**WELWYN HATFIELD BOROUGH COUNCIL
EXECUTIVE DIRECTOR - PLANNING, PUBLIC PROTECTION AND GOVERNANCE**

DELEGATED APPLICATION

Application No: 6/2022/2215/LAWP
Location: 41 Firs Wood Close Northaw Potters Bar Hertfordshire EN6 4BY
Proposal: Certificate of lawfulness for the installation of rear dormer, insertion of two rooflights to the front roof slope and one rooflight to the rear roof slope, alterations to fenestration and replacement of portico
Officer: Ms Kirsty Shirley

Recommendation: Refused

Address: 41 Firs Wood Close, EN6 4BY
 Client: Mr. & Mrs. Michael
 Drawing Title: Proposed Front & Side Elevations

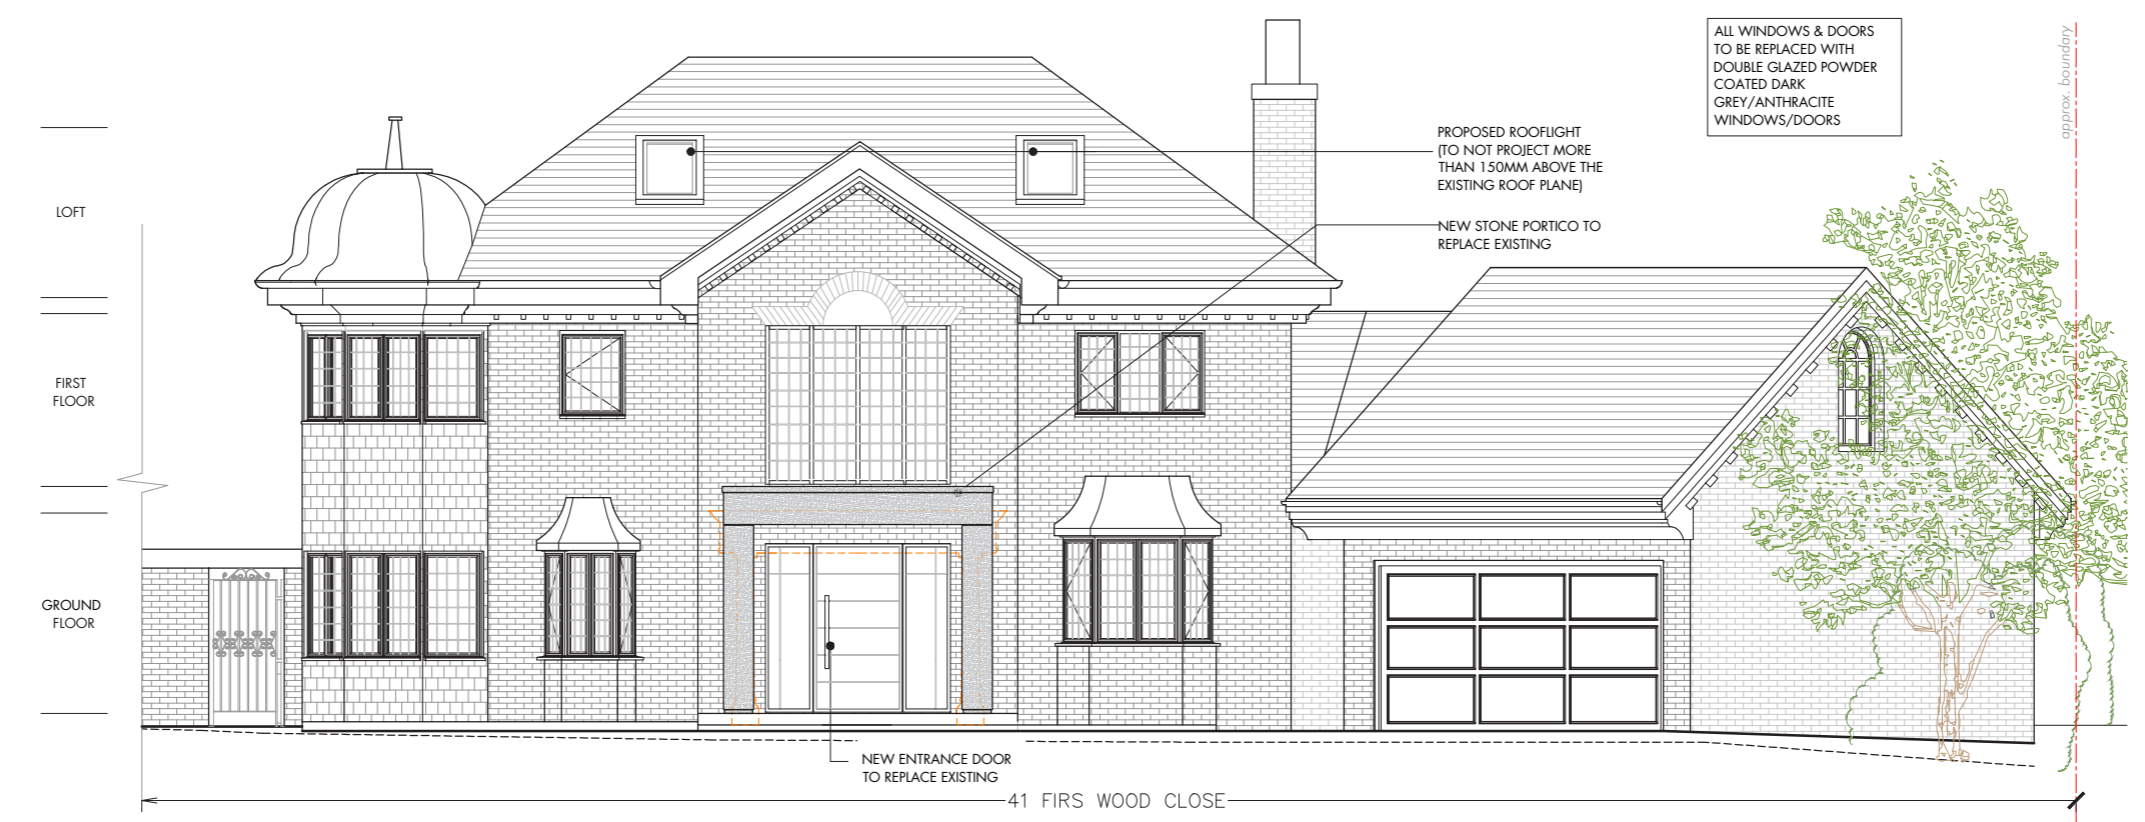
(d) any part of the structure would be within 2 metres of any boundary of the curtilage of the dwellinghouse with a highway	N	N
Conclusion		
The proposed portico would exceed 3 square metres in ground area when measured externally and would exceed 3 metres in height above ground level. The proposal therefore fails to comply with Schedule 2, Part 1, Class D (b) and (c) of the Town and Country Planning (General Permitted Development) (England) Order 2015 as amended.		
A certificate of lawfulness for the proposed works should therefore be refused.

1. The proposal fails to comply with Schedule 2, Part 1, Class D (b) and (c) of the Town and Country Planning (General Permitted Development) (England) Order 2015 as amended by virtue of the proposed portico exceeding 3 square metres in ground area when measured externally and exceeding 3 metres in height above ground level.
